**STATEMENT OF ENVIRONMENTAL EFFECTS: SECTION 75W APPLICATION TO MAJOR
PROJECT MP NO.08_0257 STAGE 1 (BUILDINGS 4 & 5) – 61 MOBBS LANE, EPPING**

Pursuant to Section 75W (1) (a) of the Environmental Planning and Assessment Act 1979, a 'modification of approval' is sought to vary Condition No. A2 pertaining to Major Project MP No. 08_0257 Stage 1 (Buildings 4 & 5) as approved on the 15 September 2010. The modification is to amend architectural plans to accommodate minor design changes to the approved architectural plans arising from design and construction compliance.

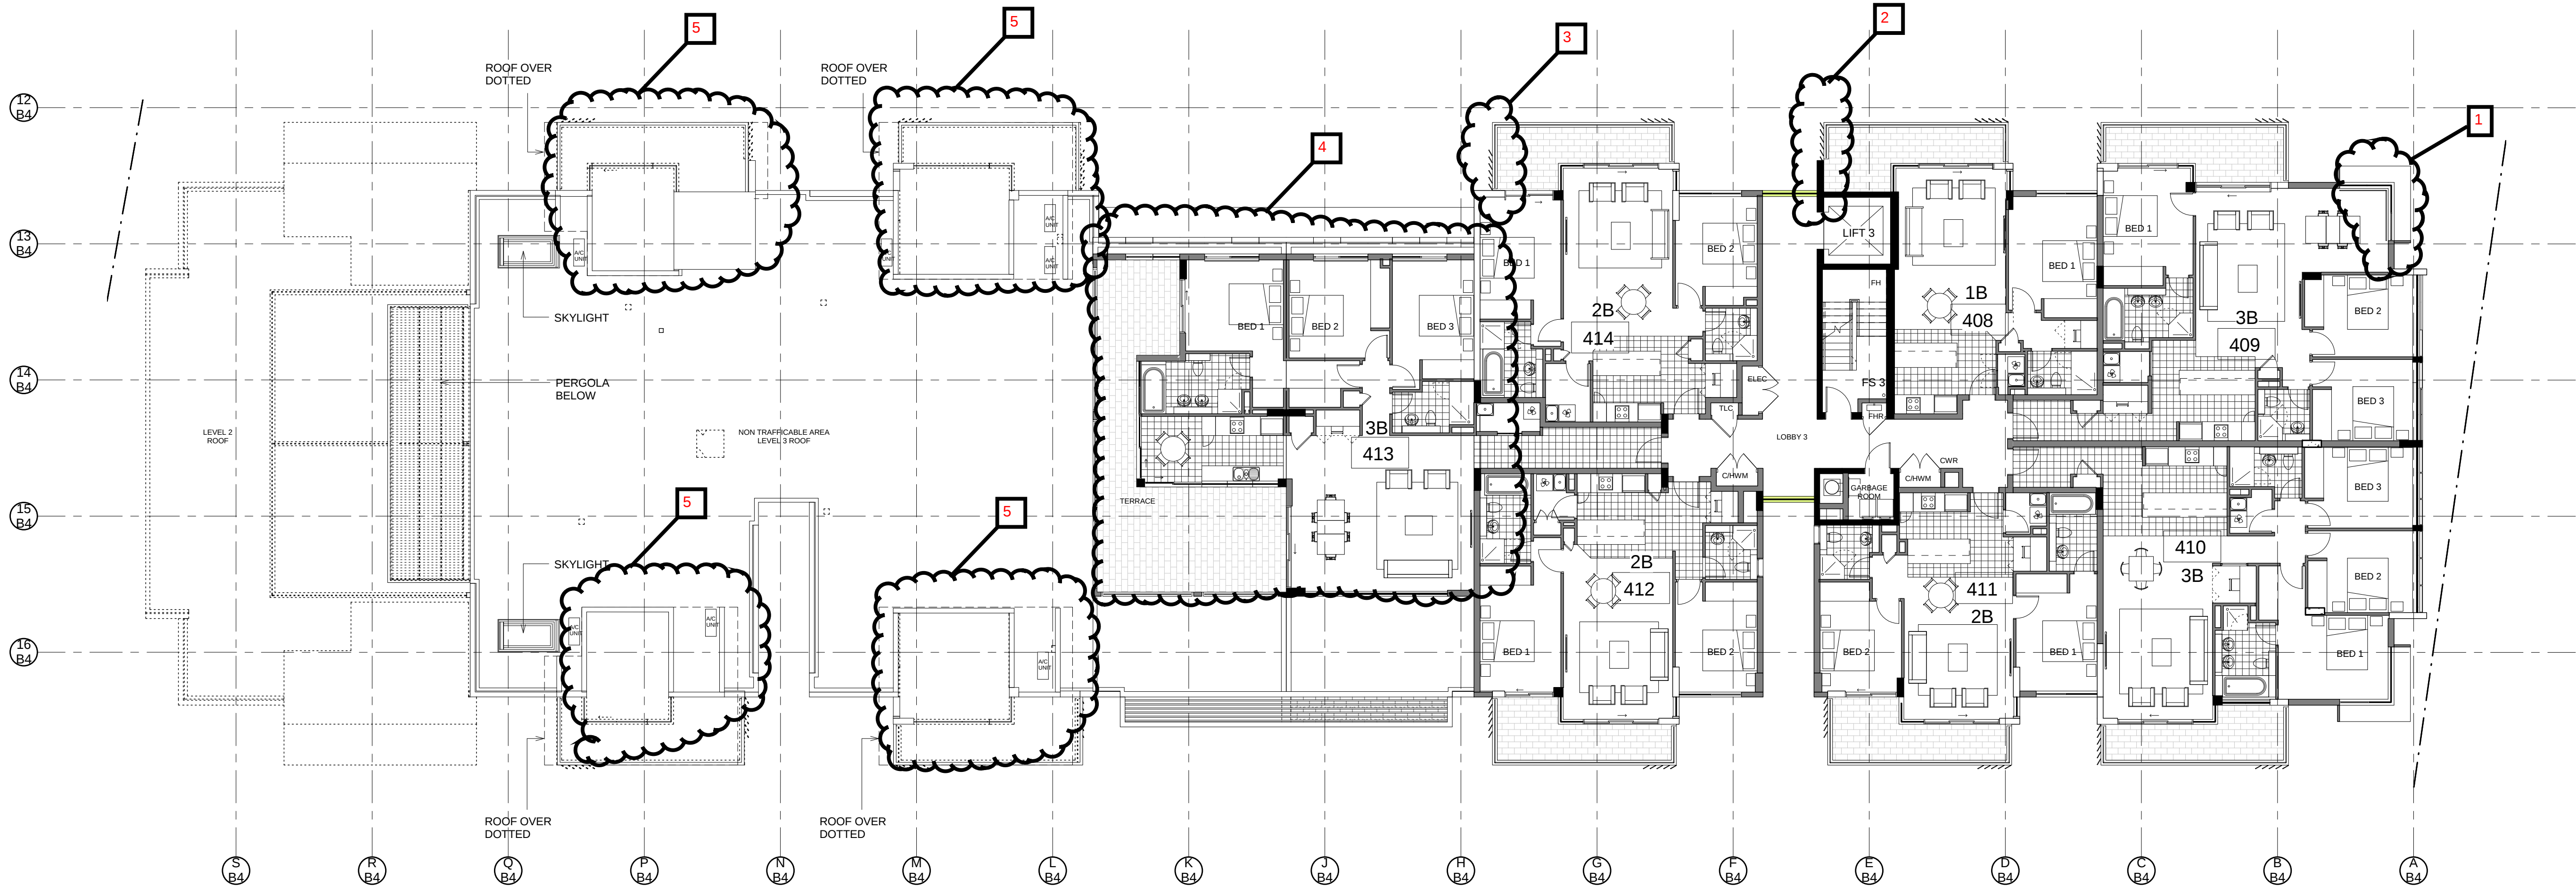
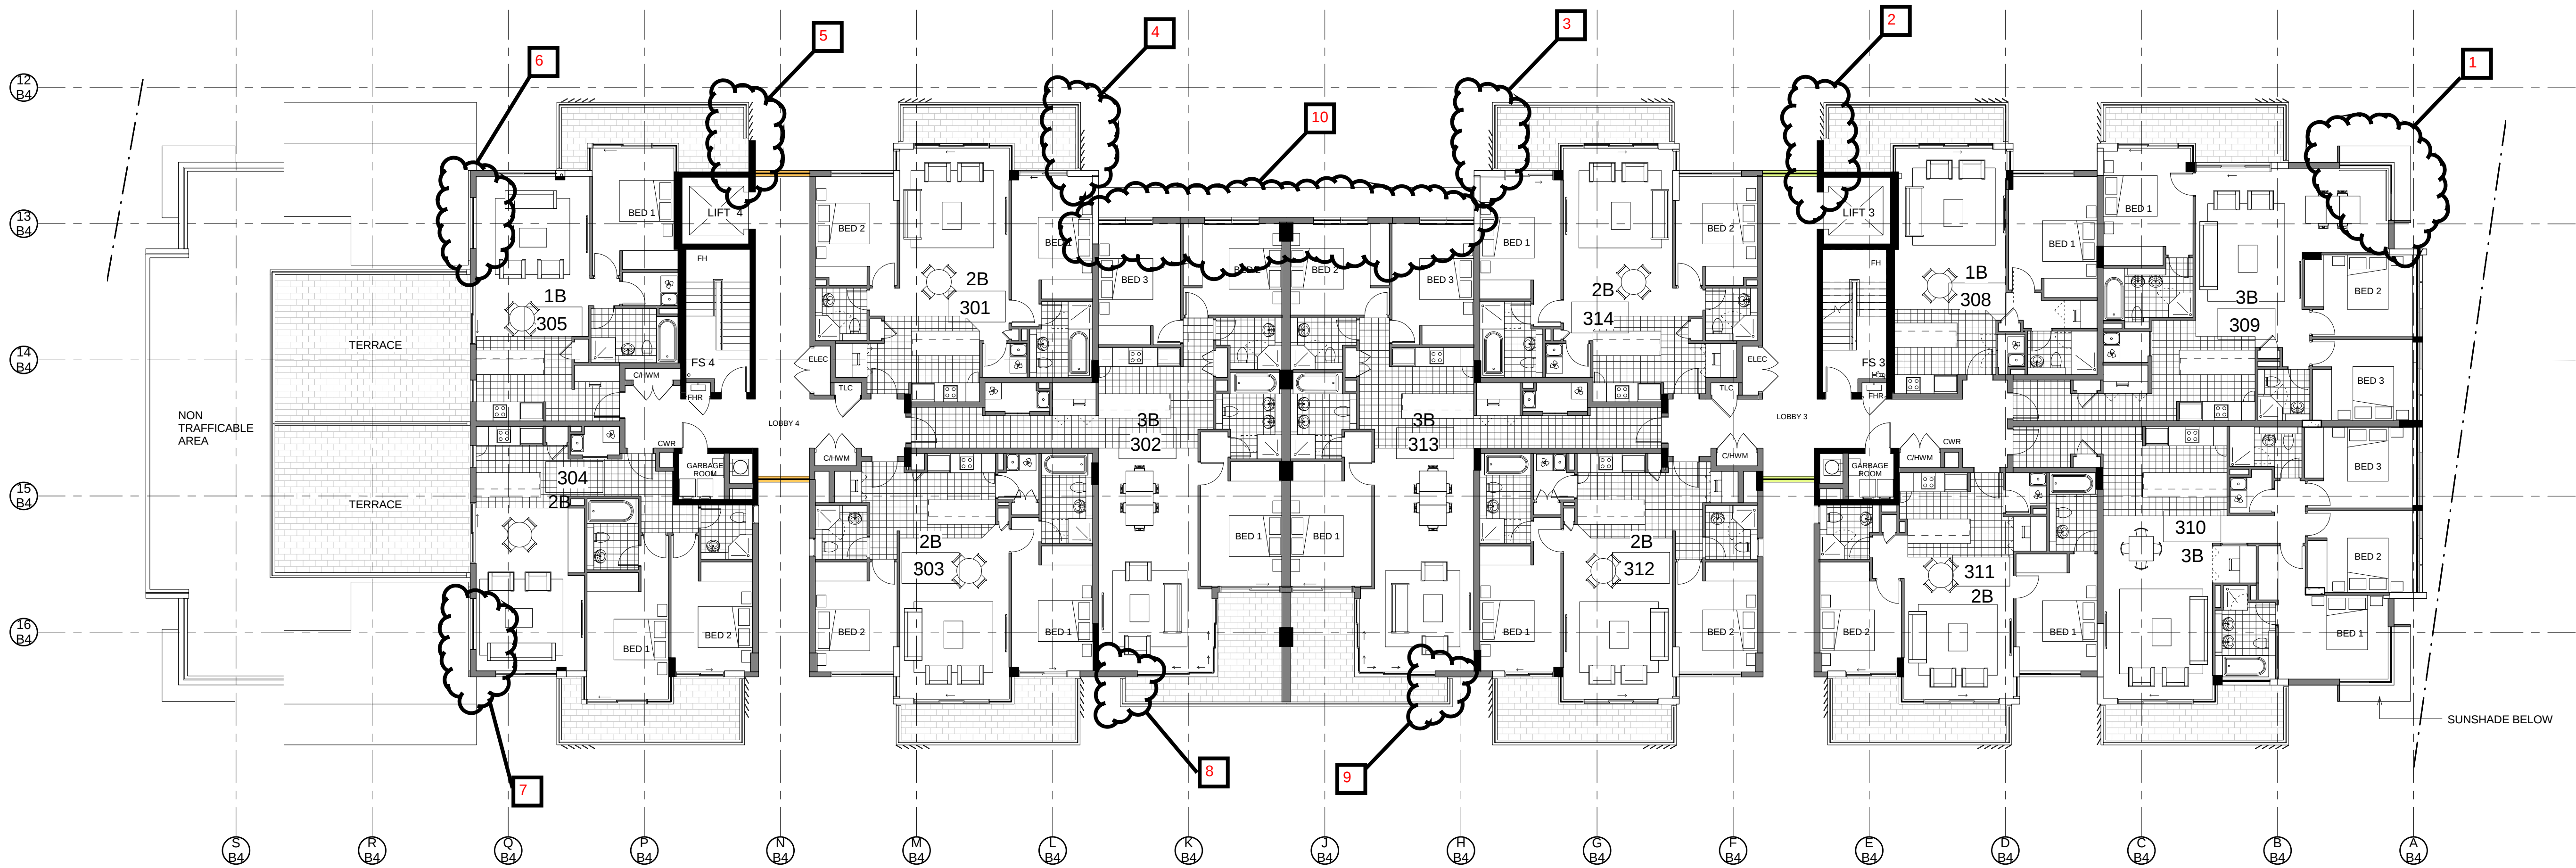
1. Unit 309 : reduce size of window and awning

2. Unit 308 : new louvre location
3. Unit 314 : new louvre location
4. Unit 301 : new louvre location
5. Unit 305 : new louvre location
6. Unit 305 : reduce window
7. Unit 304 : reduce window
8. Unit 302 : delete louvre
9. Unit 313 : delete louvre
10. Unit 302 : reconfigure window and precast wall

1. Unit 409 : reduce size of window and awning
2. Unit 408 : new louvre and concrete panel configuration
3. Unit 414 : new louvre and concrete panel configuration
4. Unit 413 : increase size of terrace and reconfigure unit
5. Change of roof area voids and reconfigure

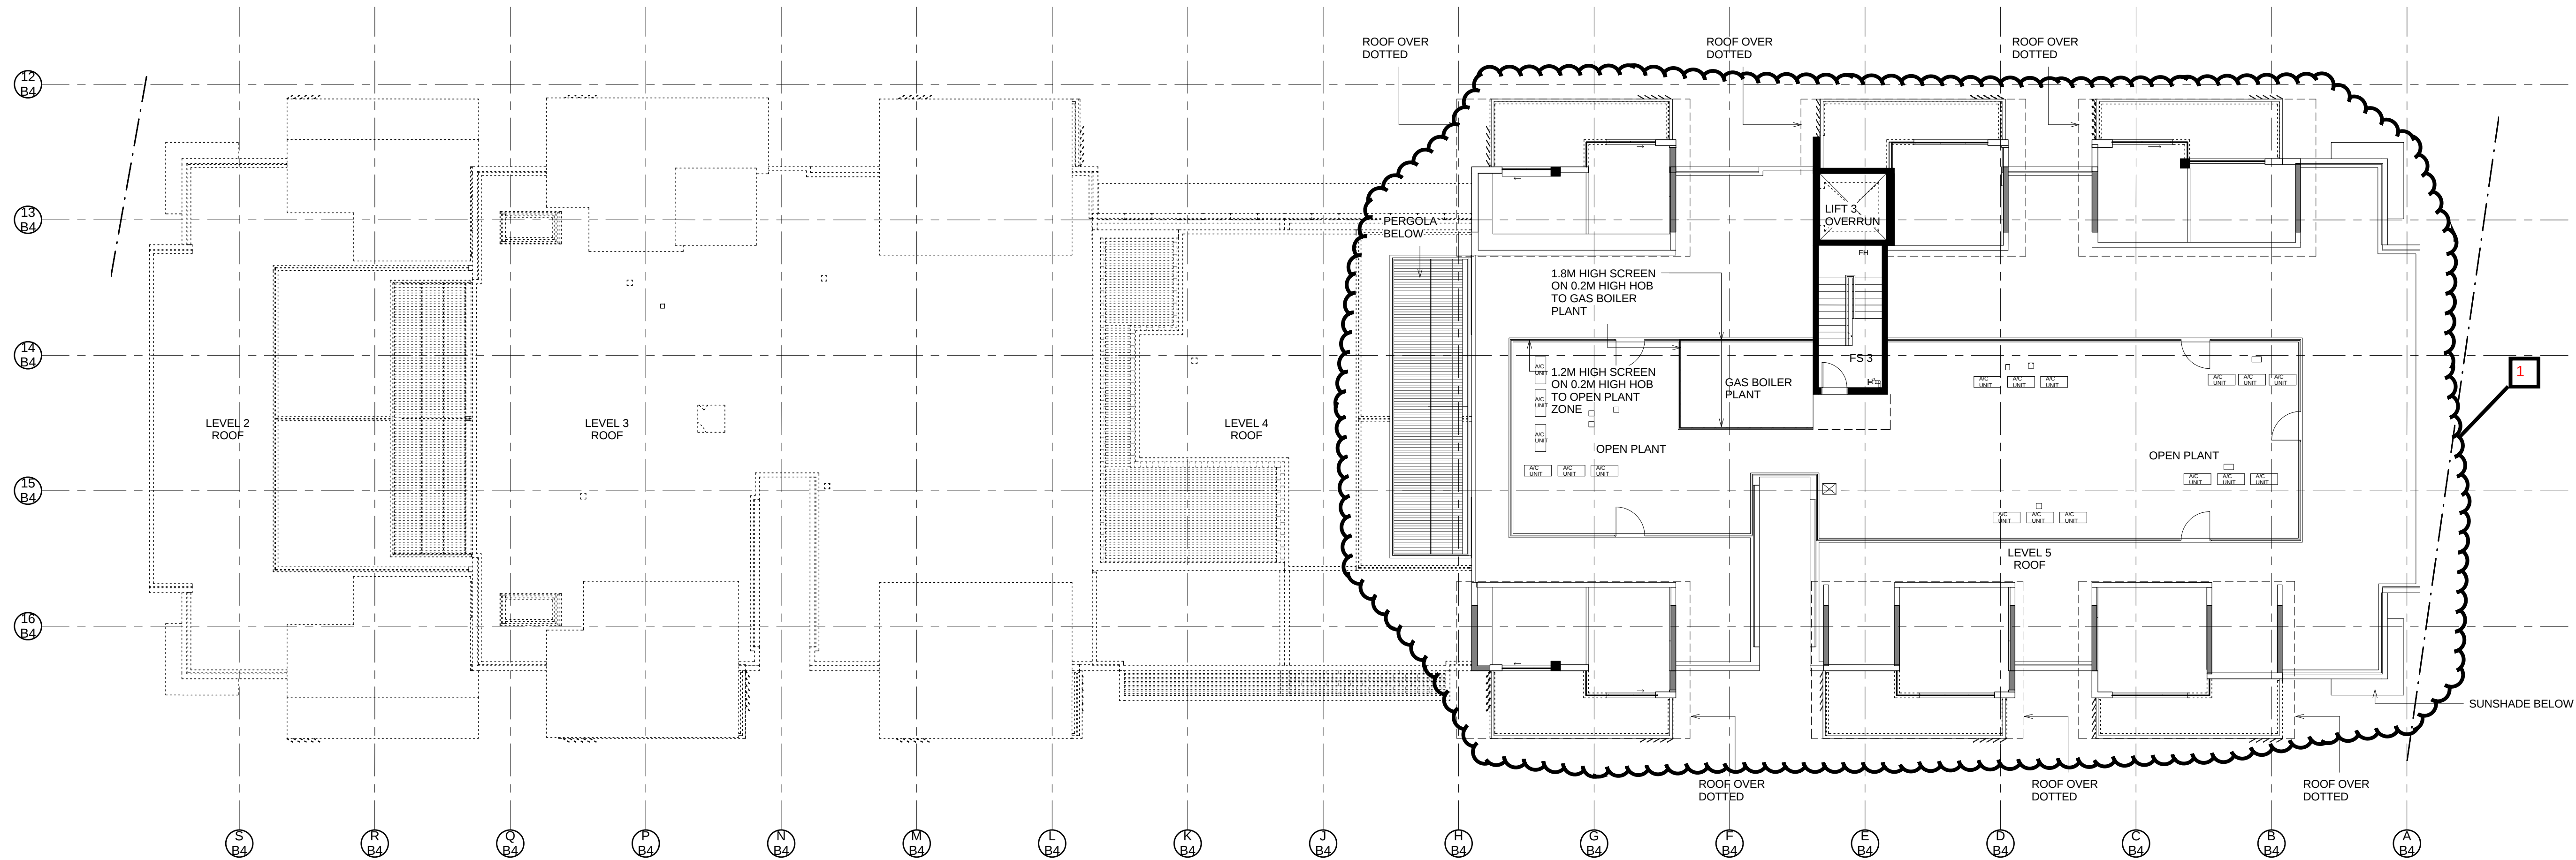
1. Unit 509 : reduce size of window and awning
2. Unit 508 : new louvre and concrete panel configuration
3. Unit 513 : decrease window size
4. Unit 512 : decrease window size
5. Change of roof area voids and reconfigure
